# KITTITAS COUNTY DEPARTMENT OF PUBLIC WORKS

## MEMORANDUM

TO: Jeff Watson, Community Development Services  
FROM: Christina Wollman, Planner II *CW*  
DATE: January 24, 2011  
SUBJECT: Walker SG-10-00014 and BLA-10-00022

The Public Works Department has reviewed the Request for Parcel Segregation and Boundary Line Adjustment Application and finds that it meets current Kittitas County Road Standards.

EXHIBIT

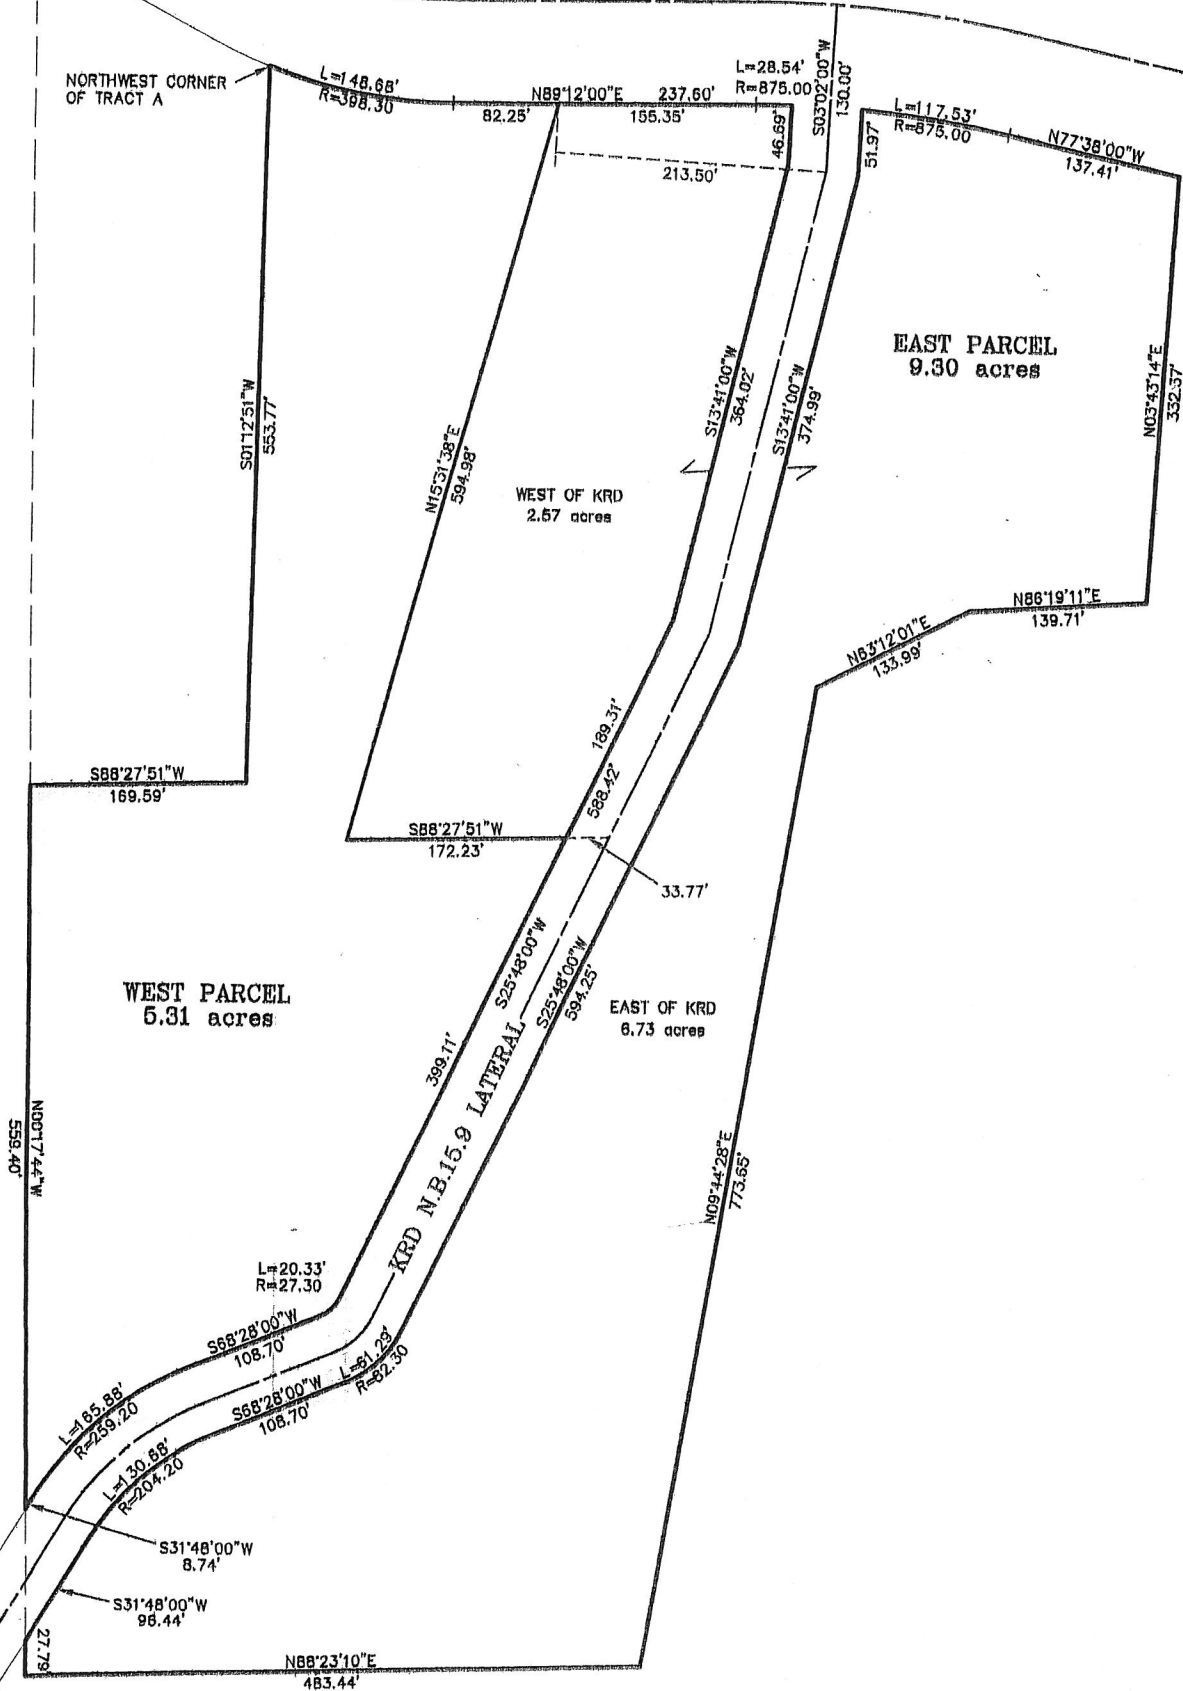
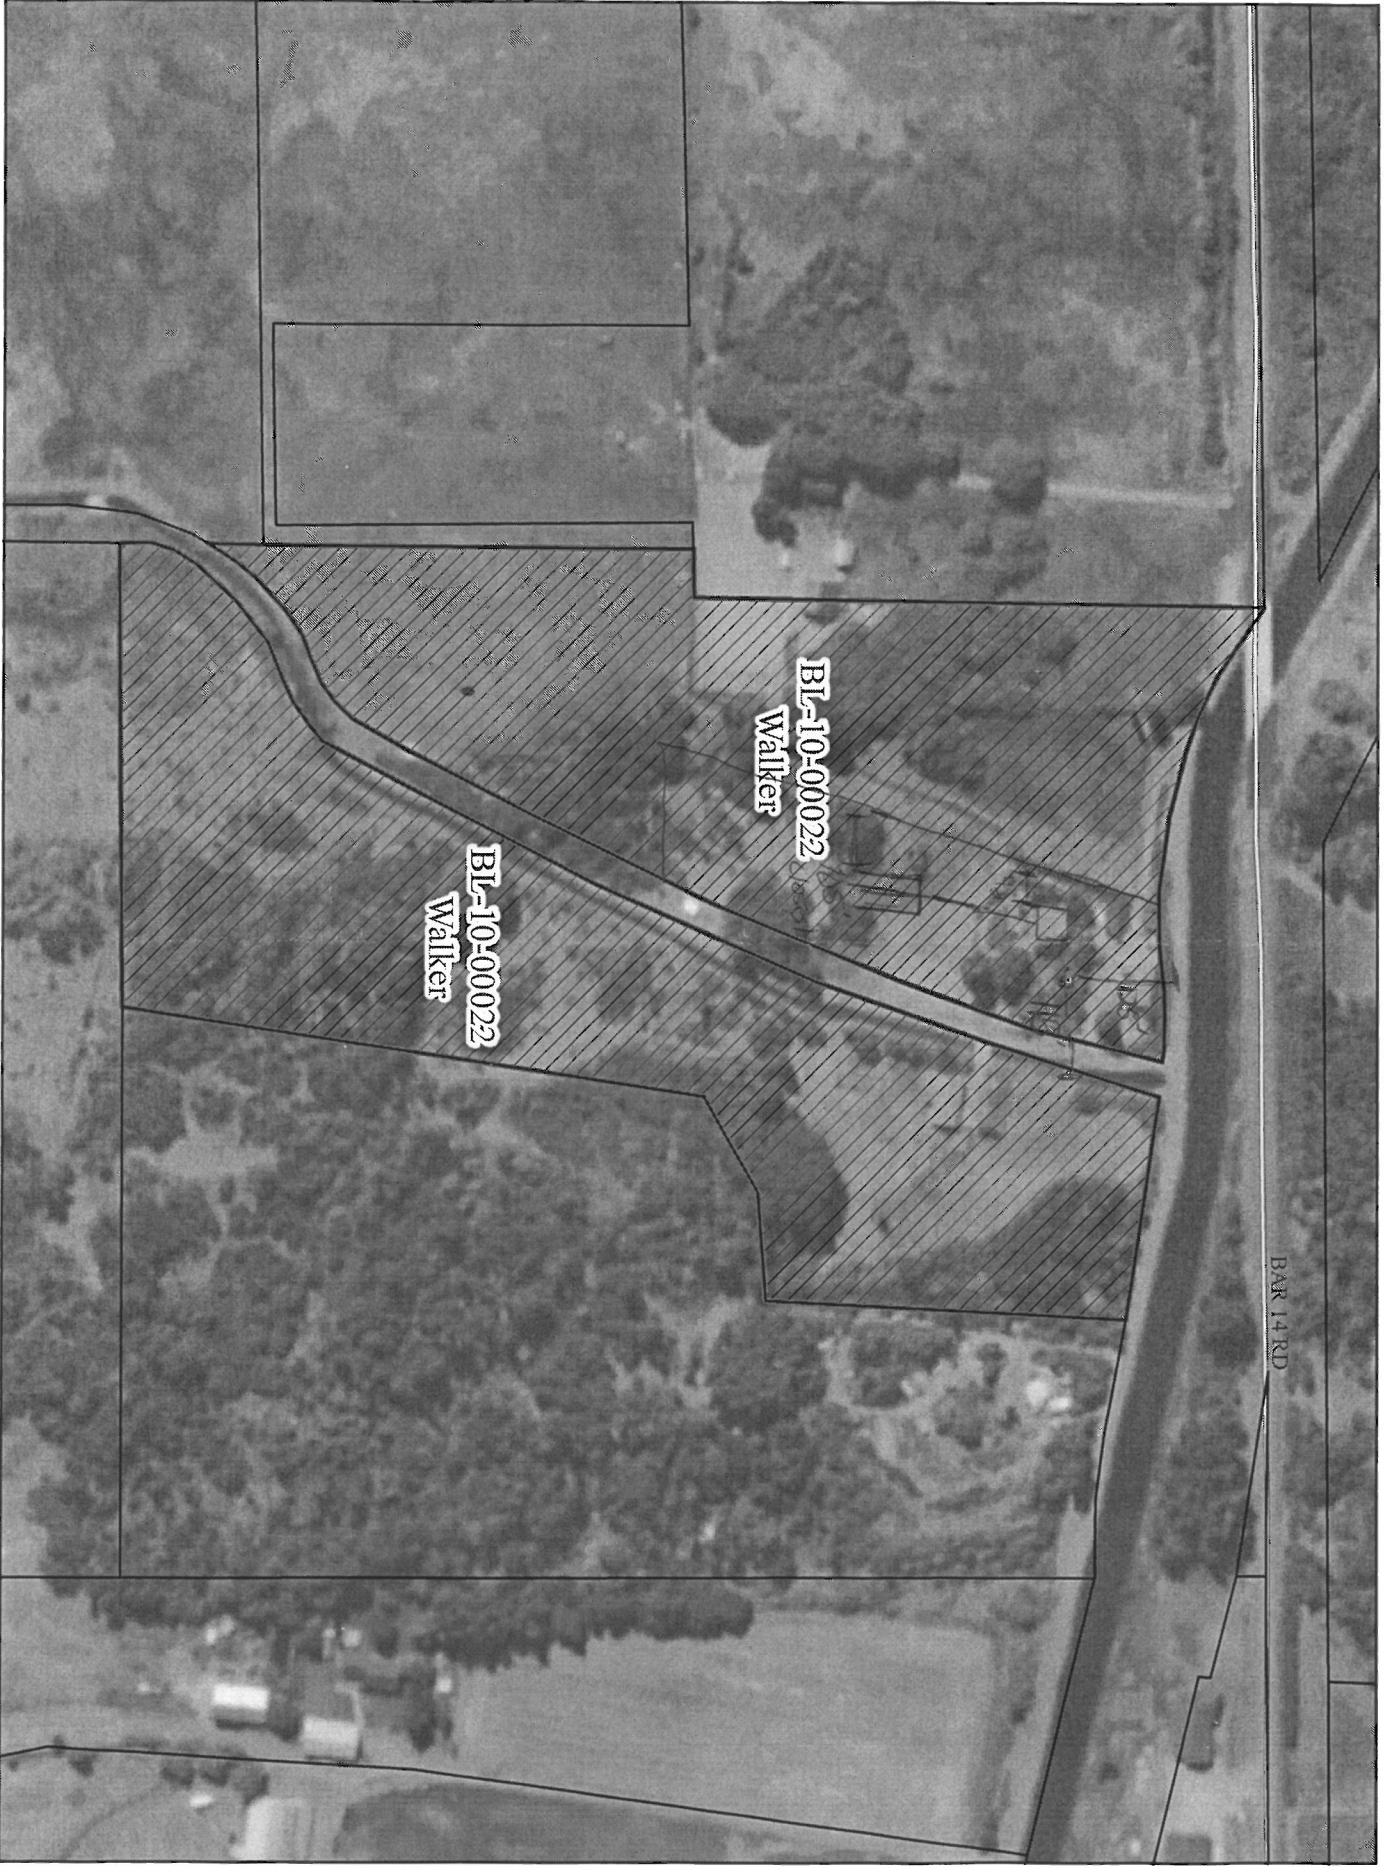
- a. The applicant must obtain an easement from KRD for the portion of driveway that uses the KRD ditch road. The easement must be obtained as soon as possible. No further development of the property will be allowed without an easement or agreement from KRD.
